79 Cortez Morrison Rd

Jim....it seems the Ag exemption is different in relation to State Building code vs Land Use regs. So, if this project is still to be a farmers market and thus sell fruits & vegetables, Planning regs are not applicable. Also, unless any clearing is taking place the below stormwater related comments are not applicable. It seems the remainder of the comments do need to be taken care of.

SITE PLAN

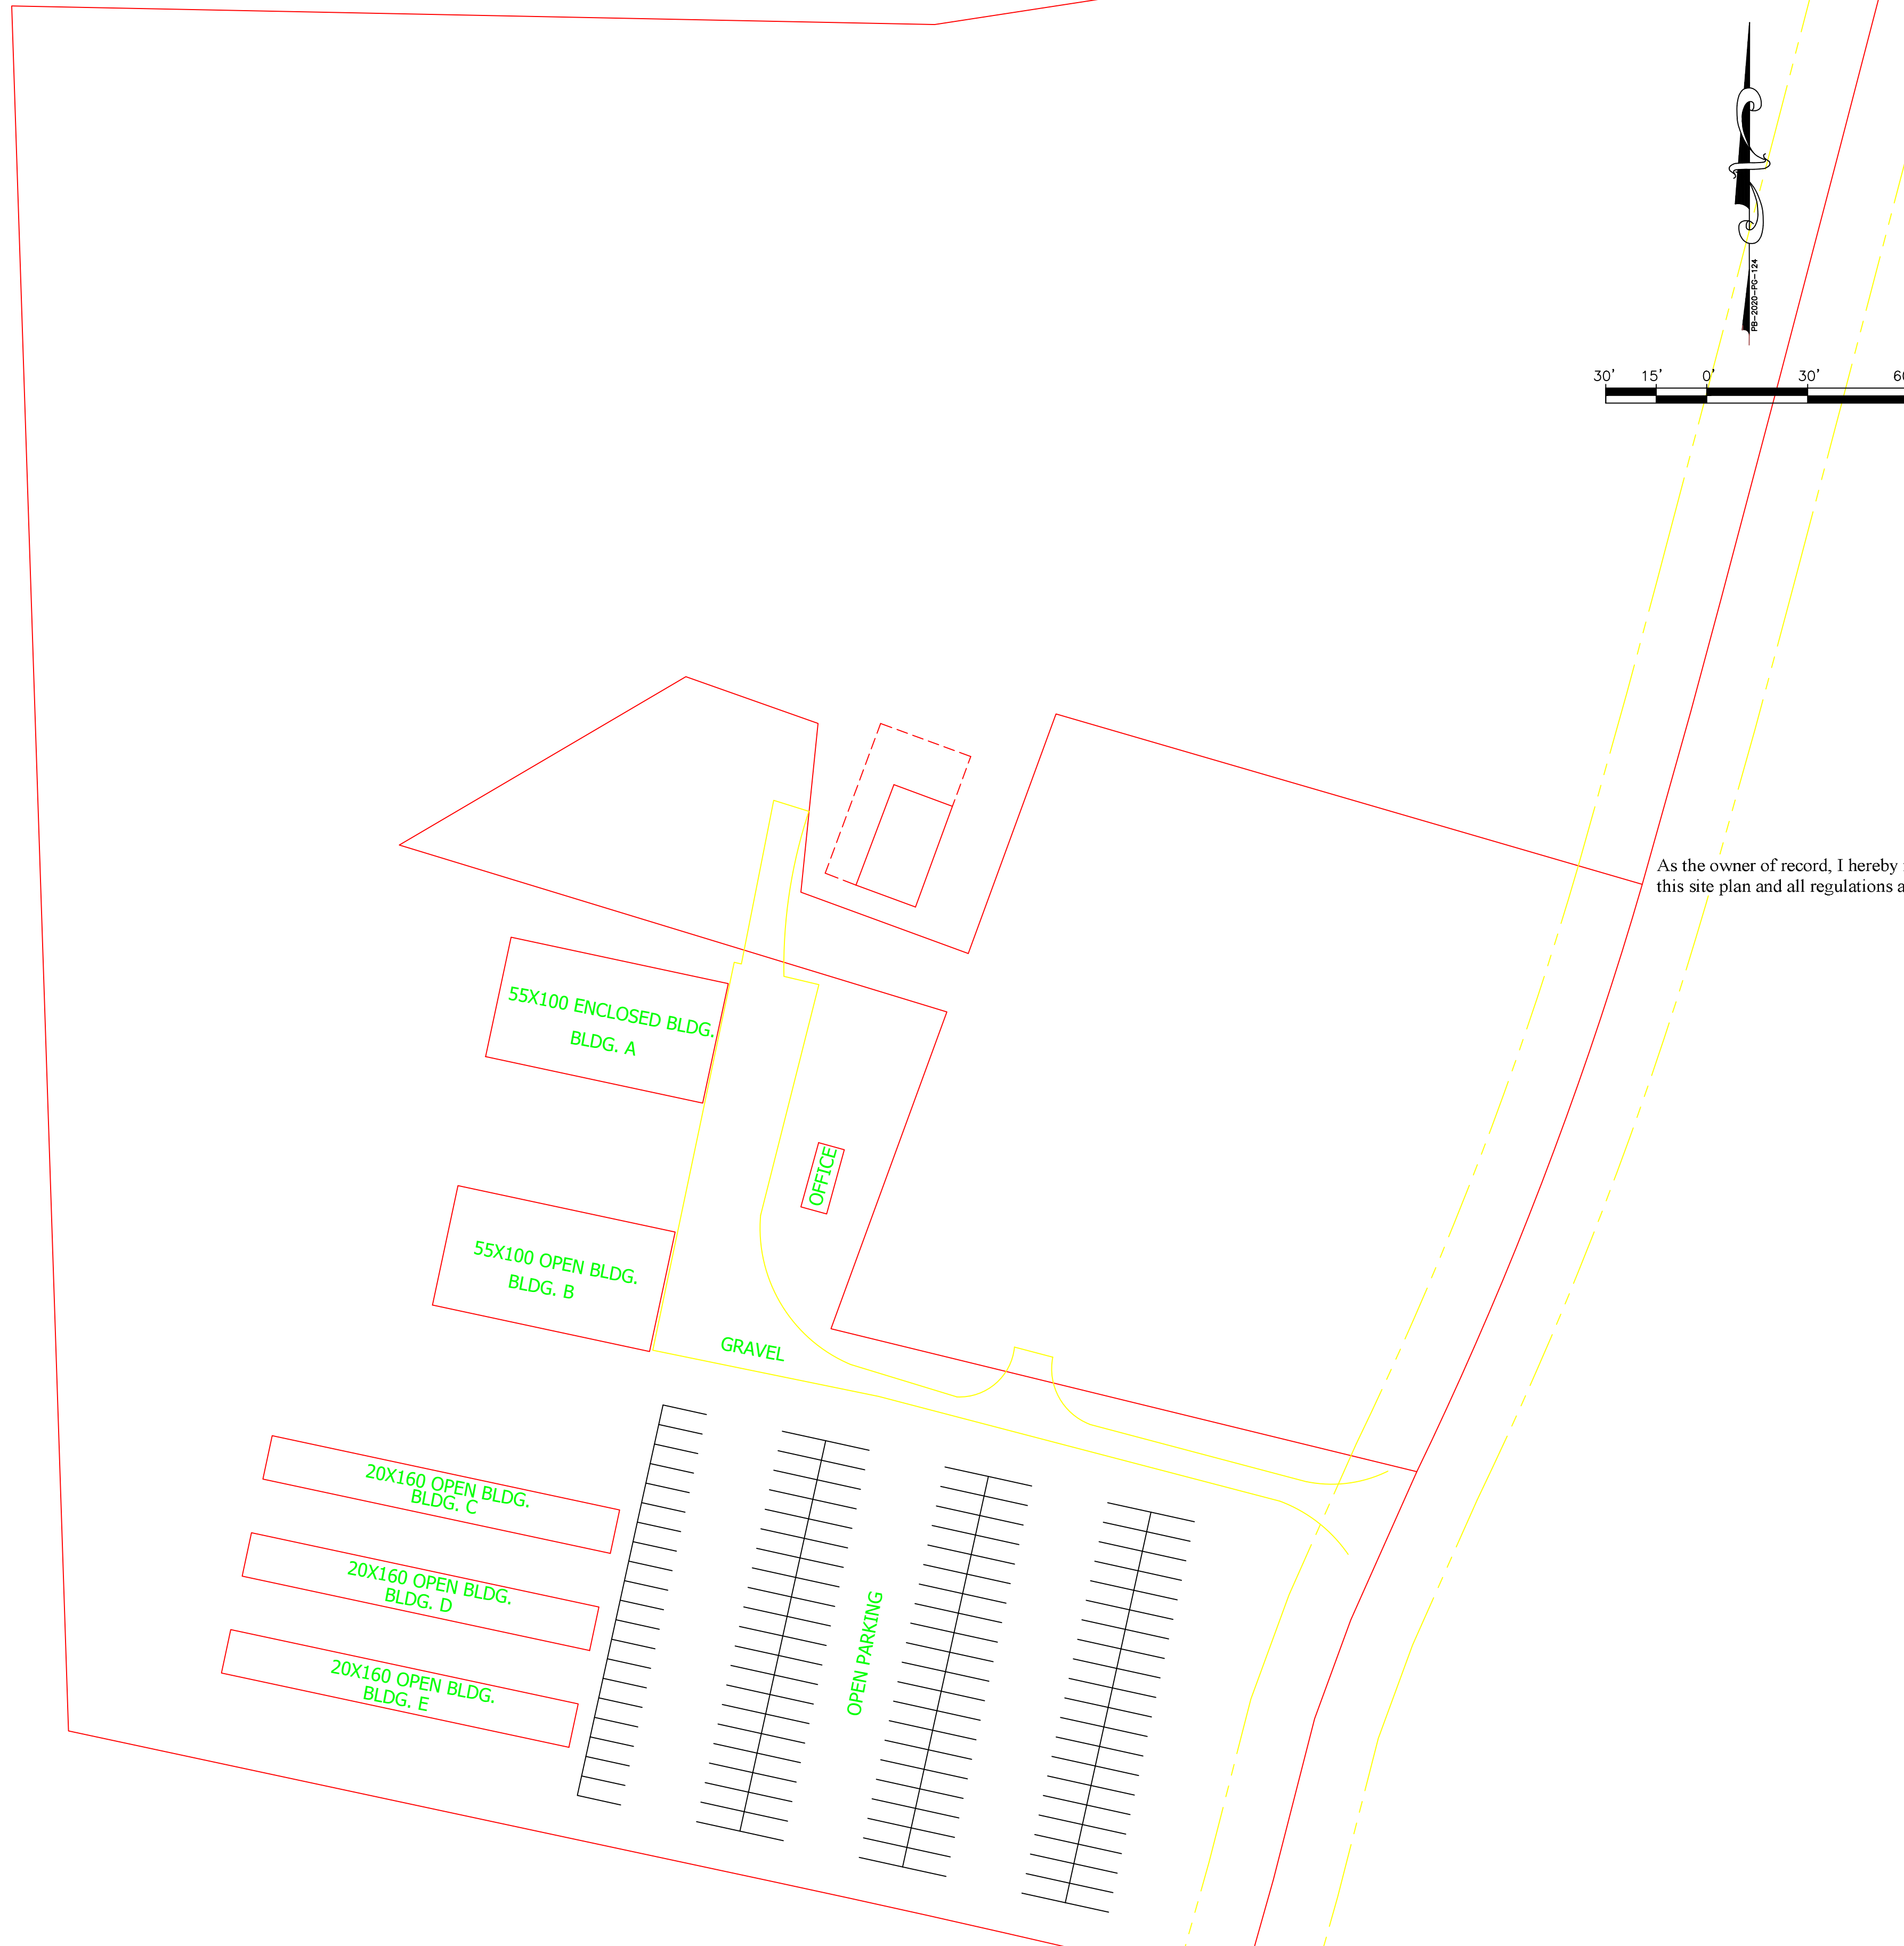
produce stand - exempt
conditional use

parking

buffering

fire hydrant

turnaround

150' drive aisle
